**RE: Coors & Central Retail
Grading and Drainage Plan
Engineers Stamp Date 7/14/14 (K10D25C)**

**Re: North Domingo Baca Multigenerational Center Phase II
Grading and Drainage Plan
Engineer's Stamp date 7-26-11 (C19/D043A)**

Re: North Domingo Baca Multigenerational Center, Phase II
Grading & Drainage Plan, Engineer's seal date 5-10-11 (C19/D043A)
SEC# 108611

GRADING AND DRAINAGE PLAN

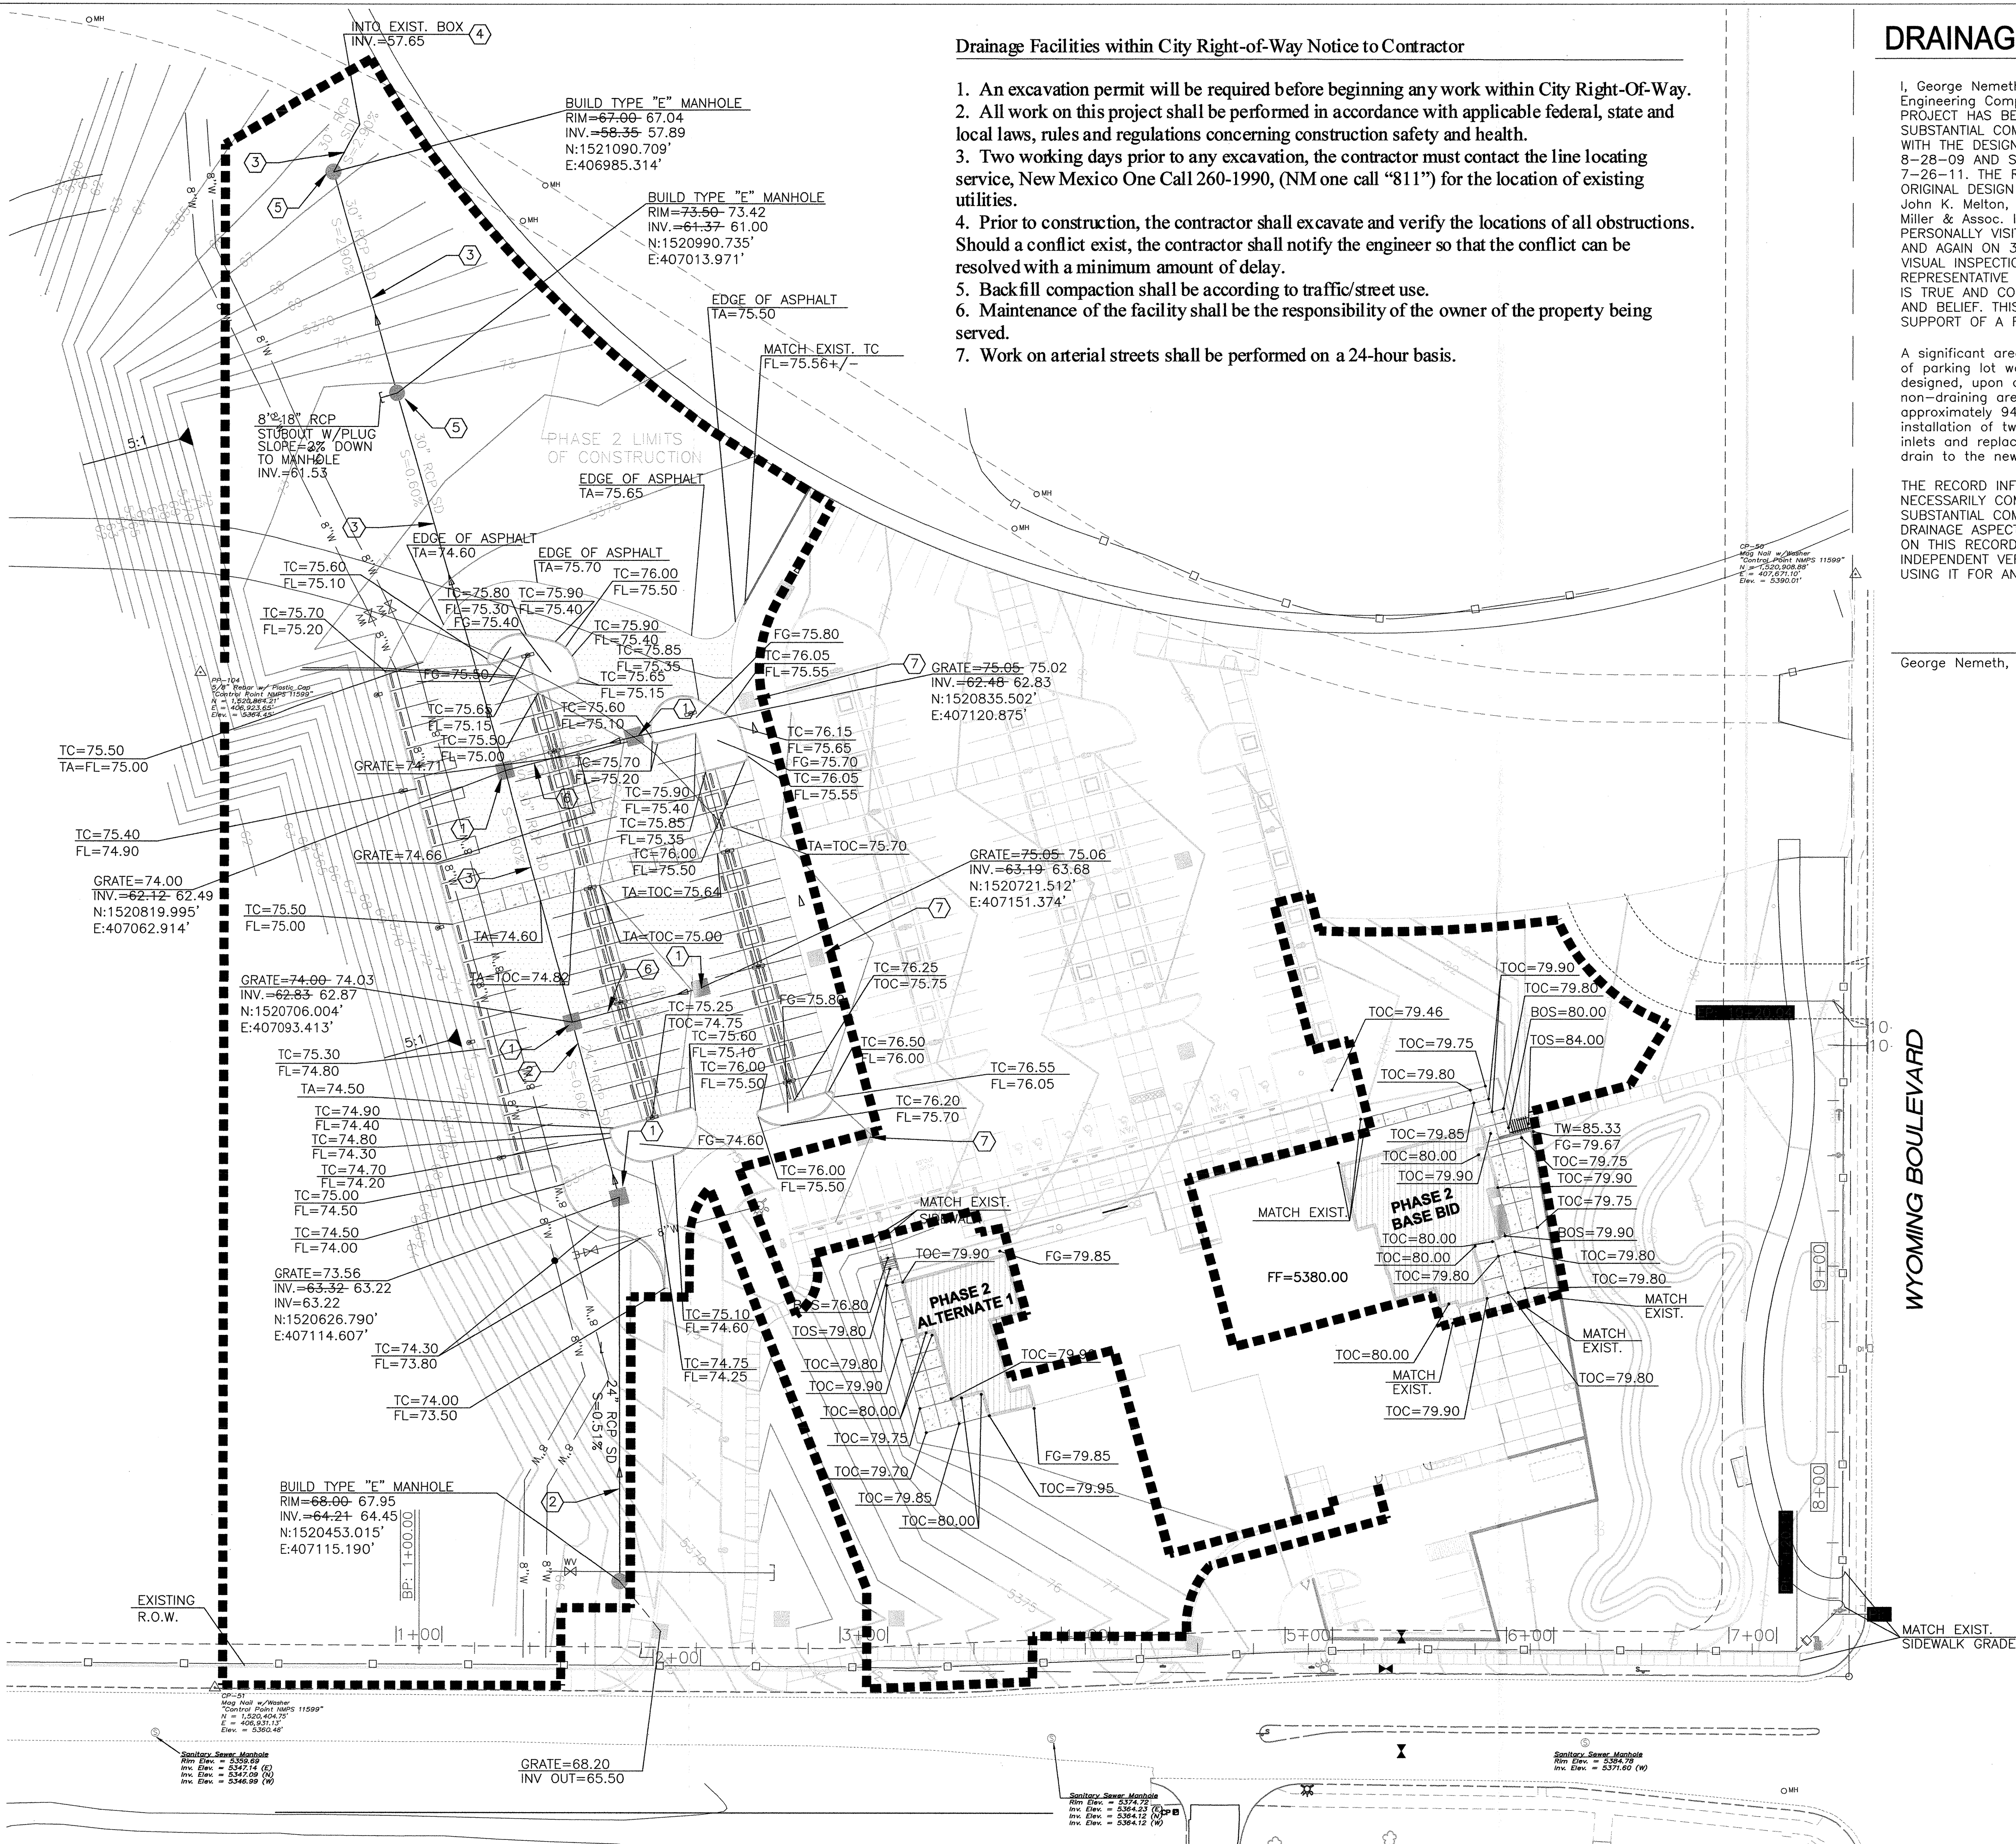
As you know, EPA is now requiring that all commercial projects are required to manage the first .44" of rain (first flush). This process should divert flows from parking lots and roof tops through a landscaped area, to reduce the particulates entering the Rio Grande River. In the future, we asking that Mark Goodwin & Associates are more aggressive in managing the first flush.

Hydrology is requesting that proposed landscape areas be depressed to retain/infiltrate the rain that falls on them.

The landscaped parking lot islands have been slightly depressed to detain and infiltrate some storm water. The aisles between parking rows where trees are planted are pervious and will also infiltrate some storm water.
